FROM: James Joseph, INTERA Inc.

SUBJECT: Project # 1002455, 07DRB-70004 Vacation of Private Easement, 07DRB-70005  
Minor – Preliminary/Final Plat Approval, Lots 3 – 7, JJ Subdivision, Located on  
San Antonio NE Between I-25 and Forest Hills NE.

DRB CASE NO: 1002455

FINAL PLAT  
PRELIMINARY PLAT  
SITE PLAN FOR BUILDING PERMIT  
SITE PLAN FOR SUBDIVISION  
VACATION OF PRIVATE EASEMENTS

Sheet Title
AMENDED SITE PLAN FOR SUBDIVISION
Drawn By: PESLUKAI, S.A.
Checked By: T. OTT

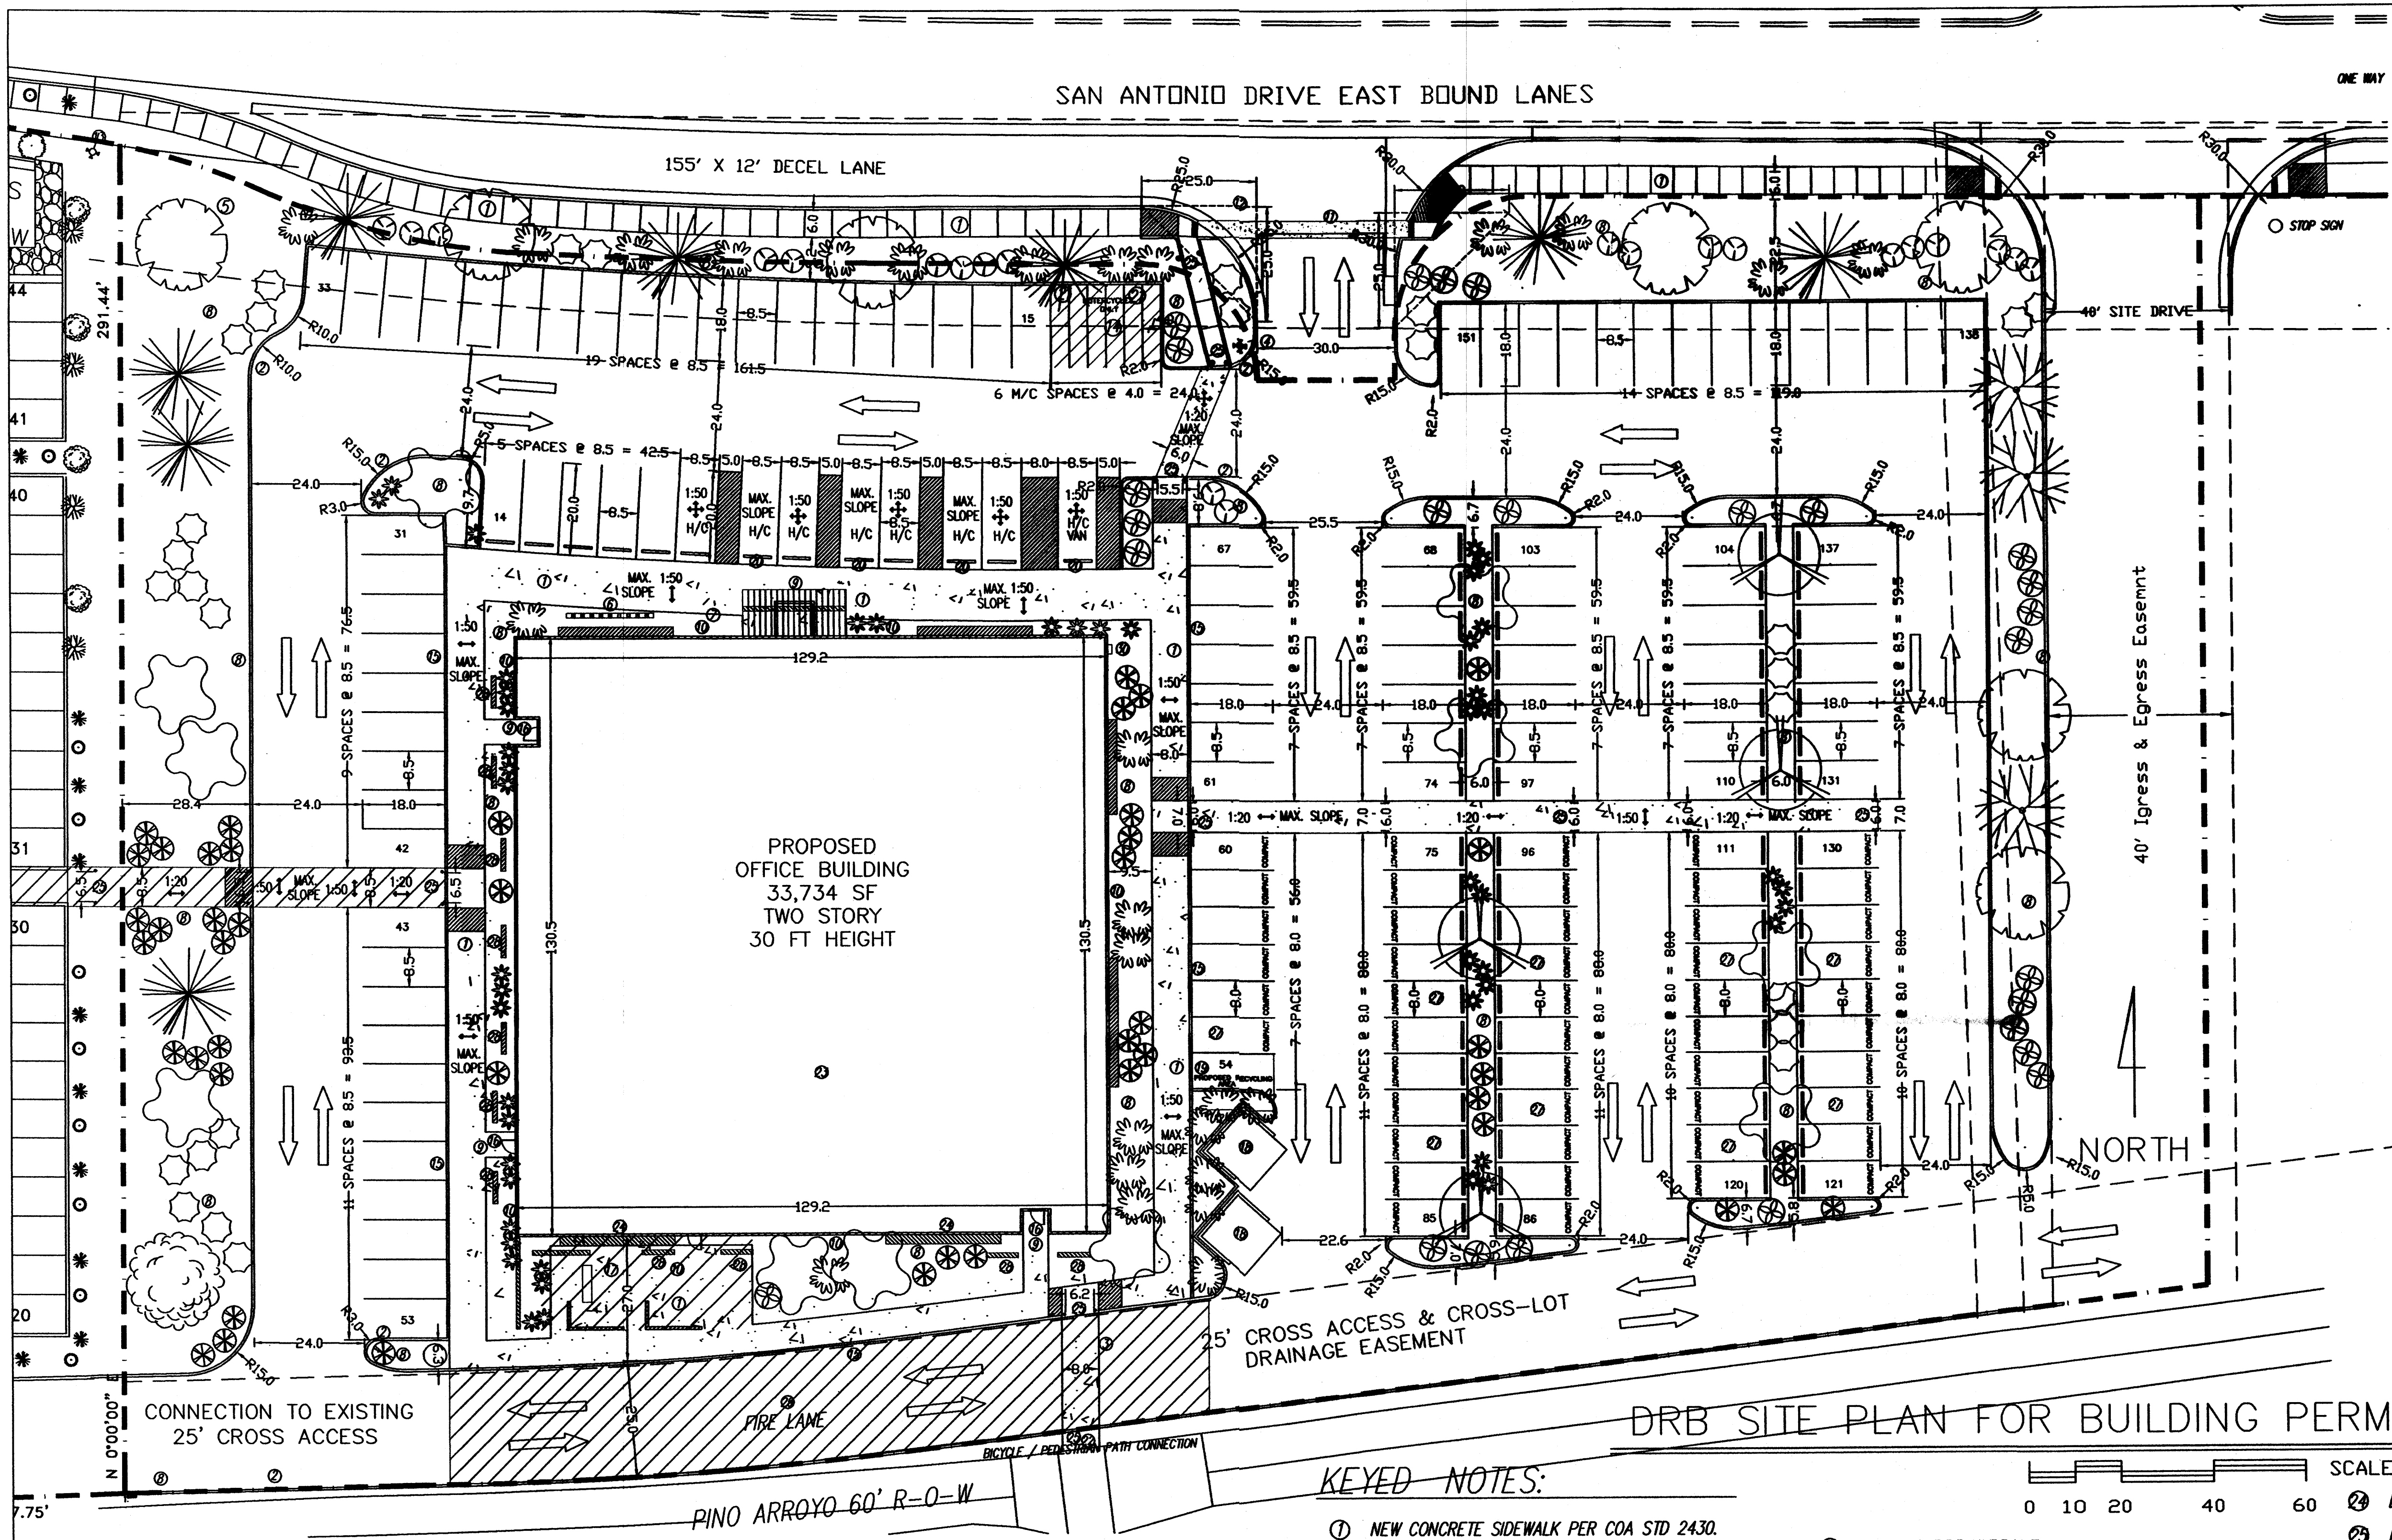
- ✓• A new ingress/egress easement must be dedicated to replace the vacated easement between lots 2 and 3

Sheet Title
DRB TRAFFIC CIRCULATION LAYOUT
FOR BUILDING PERMIT

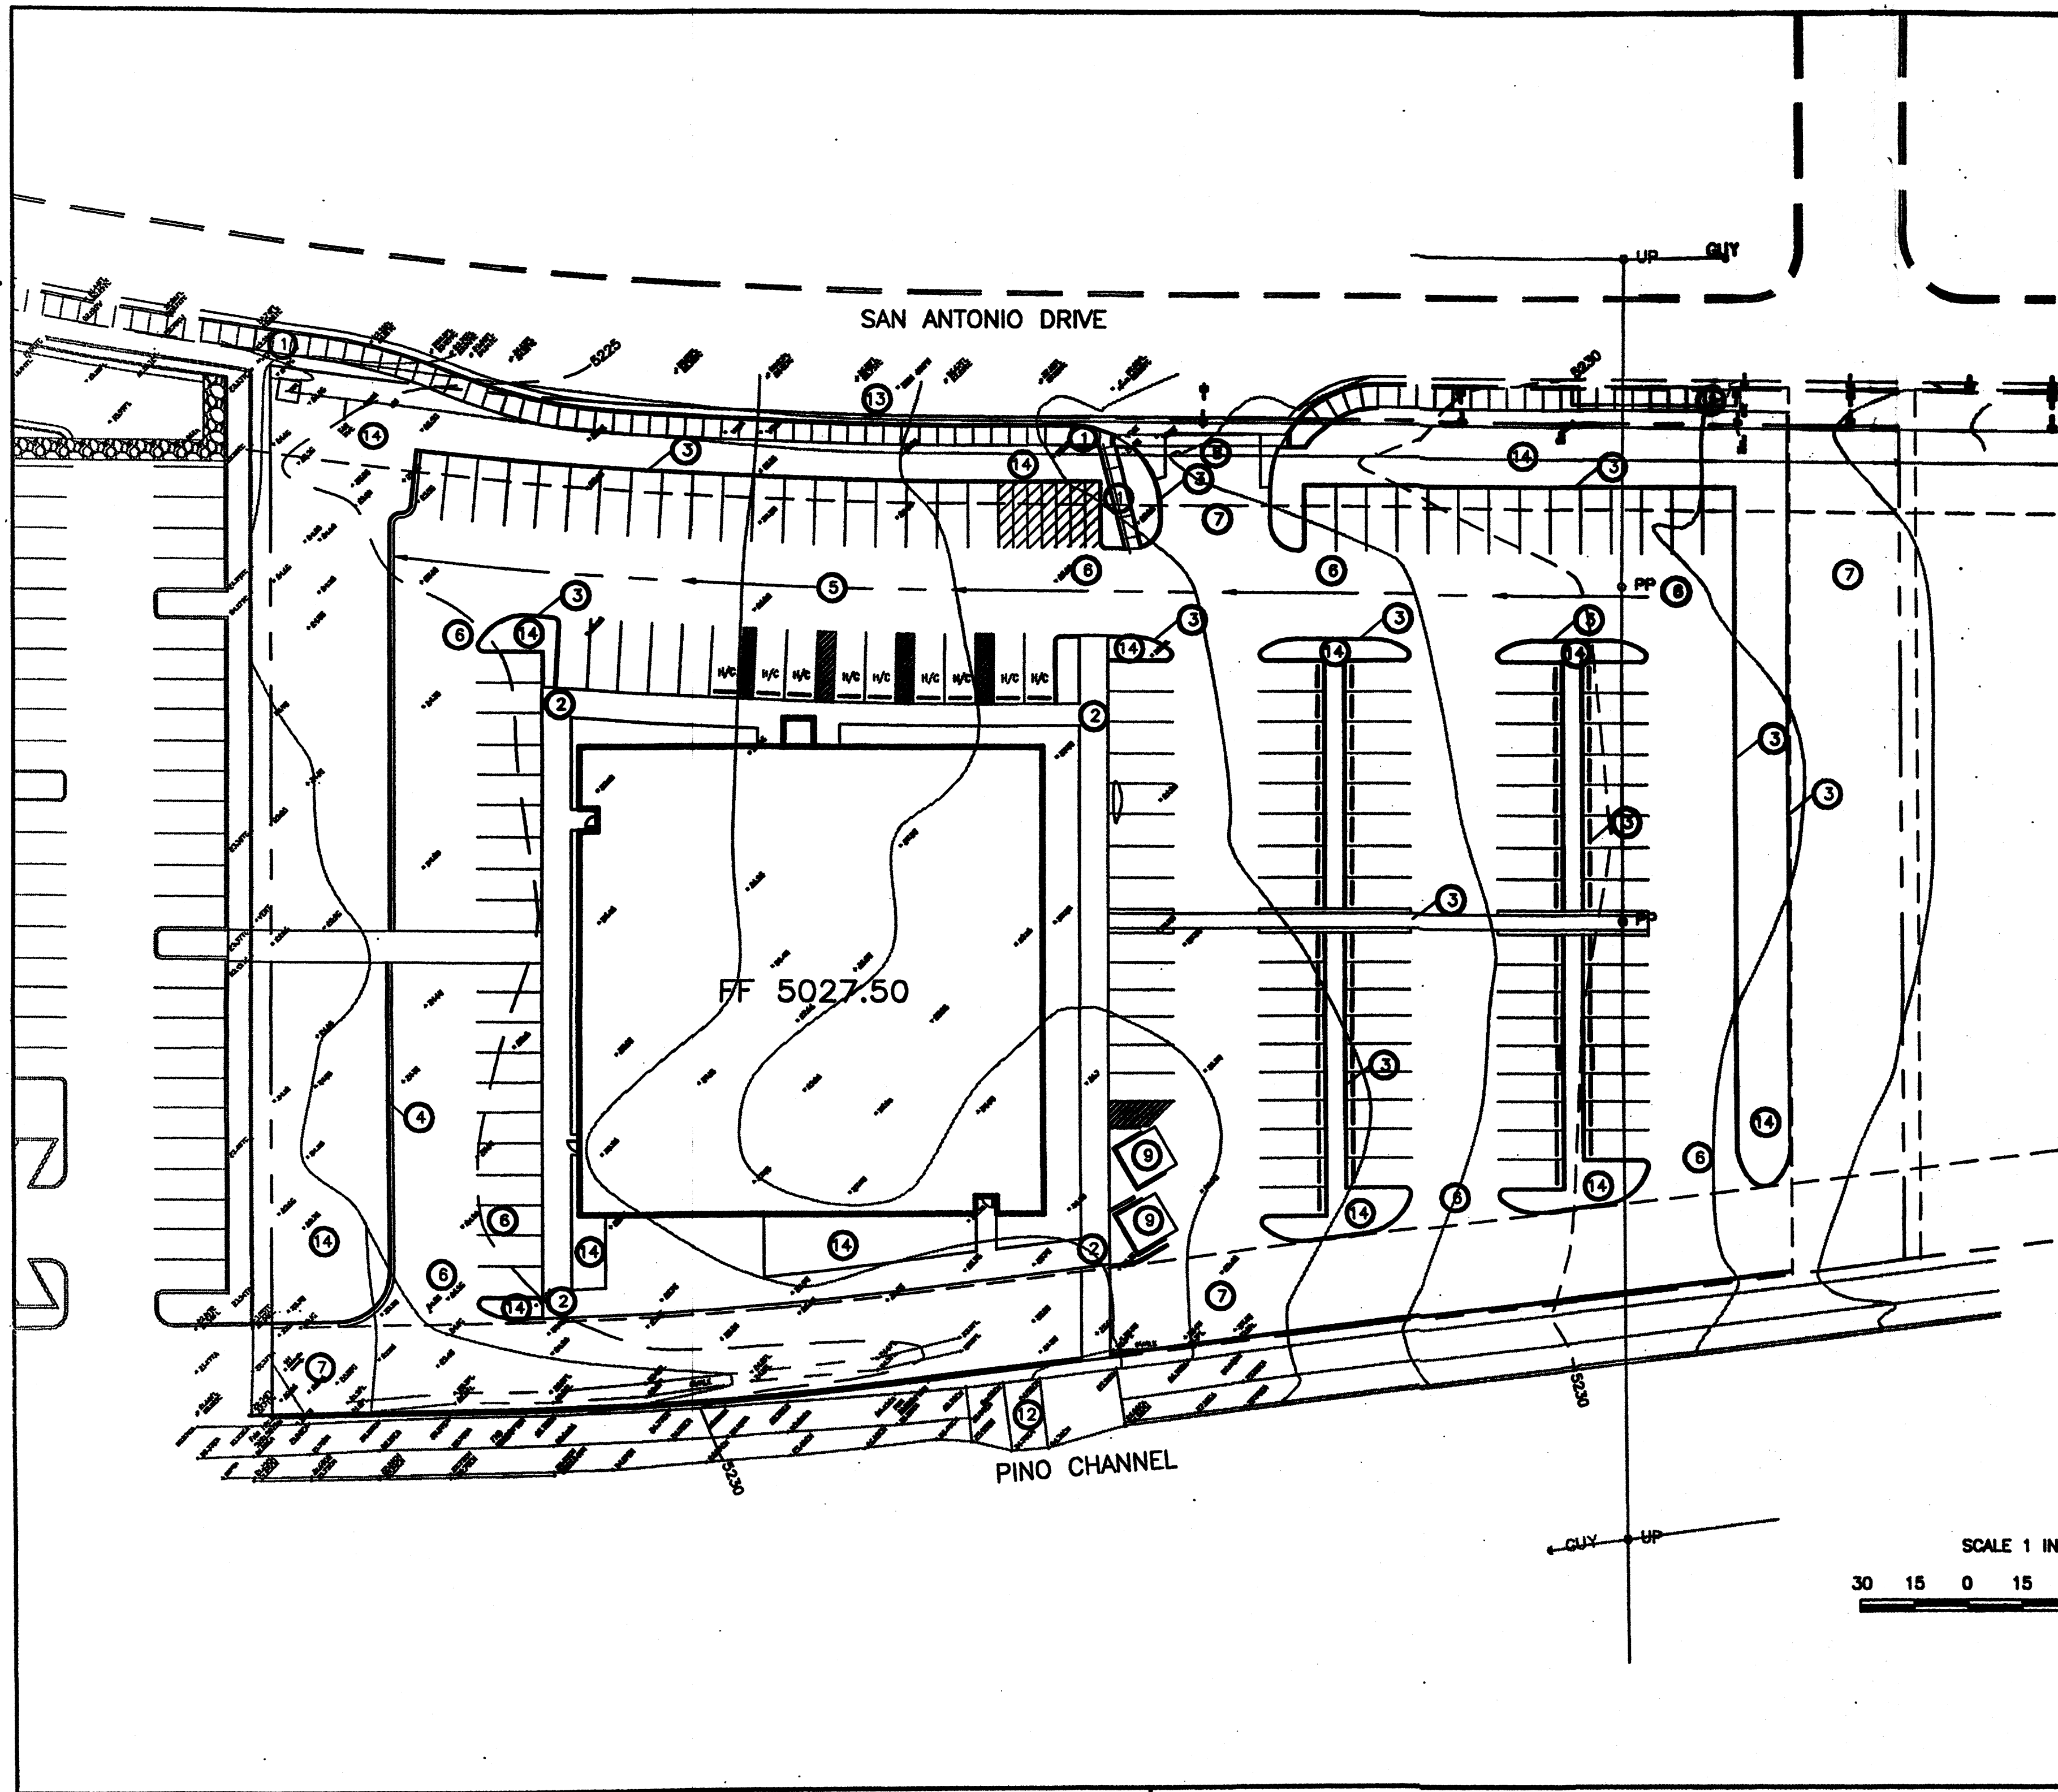
- ✓• Call out the width of the keyway.
- ✓• For passenger vehicles, the minimum end island radius is 15 feet.
- ✓• Call out the width of all sidewalk and crosswalks. A minimum width of 6 feet must be maintained.
- ✓• The wheelchair ramps must line up at the deceleration lane.
